**PLANNING APPLICATION CONSULTATION RESPONSE**

<b>Application Number:</b>	3/2024/0020
<b>Proposal:</b>	Erection of proposed extension to the dairy warehouse; new staff parking; landscaping across the whole site and associated works.
<b>Location:</b>	Alston Dairy Alston Lane Longridge PR3 3BL

### **Objection 1 – Inadequate Surface Water Sustainable Drainage Strategy**

Figure 3. Outline drainage design and details (available full size in Appendix D)

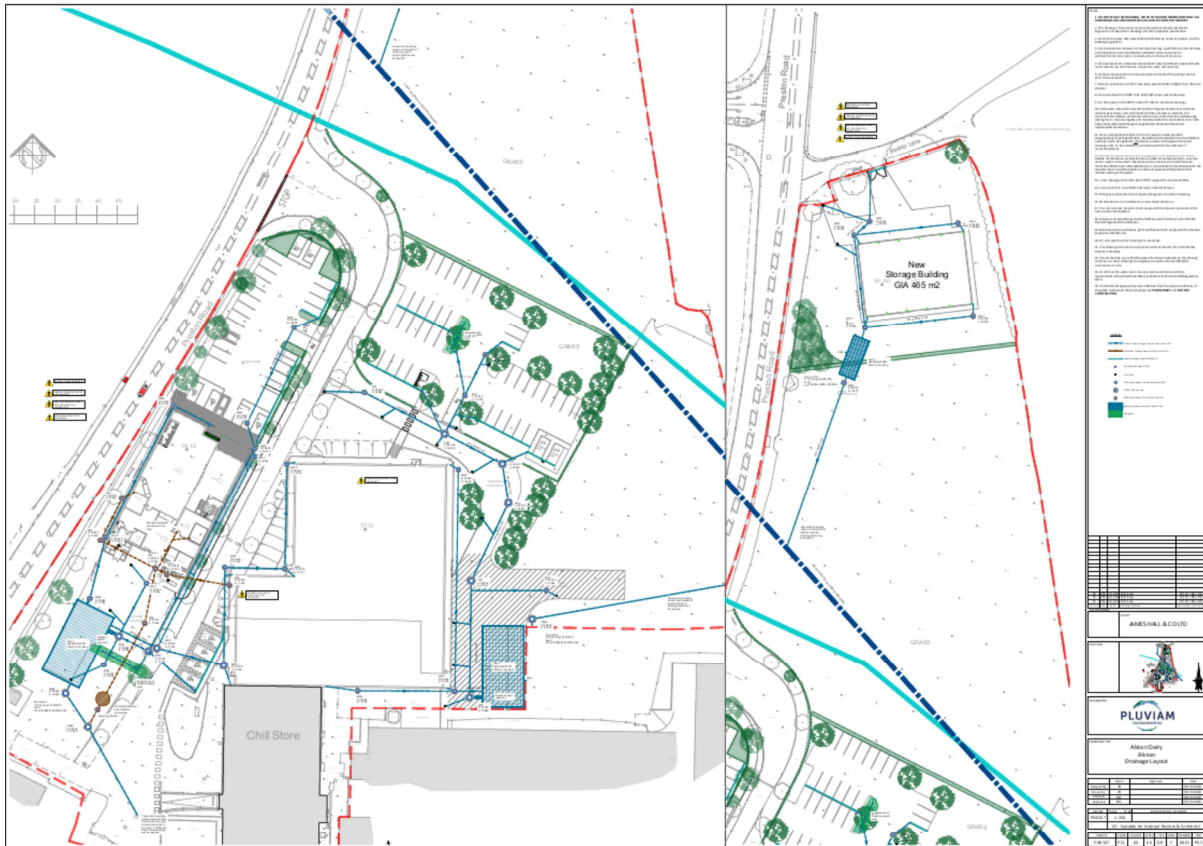
**Discharge Points** – the proposed drainage strategy involves three distinct catchments, each with their own attenuation tank and discharge point. As such, each of these systems must be considered independently of the overall drainage strategy. The applicant must provide an indicative drainage strategy with this application for full planning permission that demonstrates that each of the proposed drainage systems can achieve satisfactory arrangements to facilitate the discharge of surface water from the site.

- The drainage system that serves the proposed storage compound to the north is shown to outfall to the culverted watercourse within the site boundary. This is acceptable in principle, with further details to be provided at the detailed design phase such as a survey of the culvert to confirm its capacity and condition.

- The drainage system which serves the proposed extension of the existing facilities also proposes to outfall to the culverted watercourse, however this connection is off the edge of the included drainage layout and would appear to connect to the culvert outside of the red edged boundary, potentially in third party land. While this may be acceptable in principle, the applicant must clarify the relevant land ownership and any required agreements to facilitate the proposed connection.

- The drainage system which would serve the proposed farm shop would outfall to the existing drainage system. It appears that no information relating to the existing drainage system has been provided in the submitted details, however. The submitted drainage layout plan is labelled "connection to existing surface water manhole if confirmed to connect to watercourse and if the invert is sufficiently deep. These qualifying conditions must be proven prior to the detailed design phase, or, if that cannot be achieved, a "Plan B" strategy for this system must be provided.

- **Pumping Stations** – the submitted drainage layout plan includes three discharge points, each of which are labelled "pumping station may be required". In accordance with standard S12 of the Defra Technical Standards for SuDS, pumping surface water should be avoided wherever a gravity connection can be achieved. The proposal to pump surface water must be accompanied by a robust justification as to why a gravity fed system is not feasible. The submitted drainage strategy does not explicitly state that pumping stations will be used, however, should pumping be deemed necessary through the detailed design phase due to the lack of fall across the site, the applicant should be aware that a robust justification must be provided with their final drainage strategy.
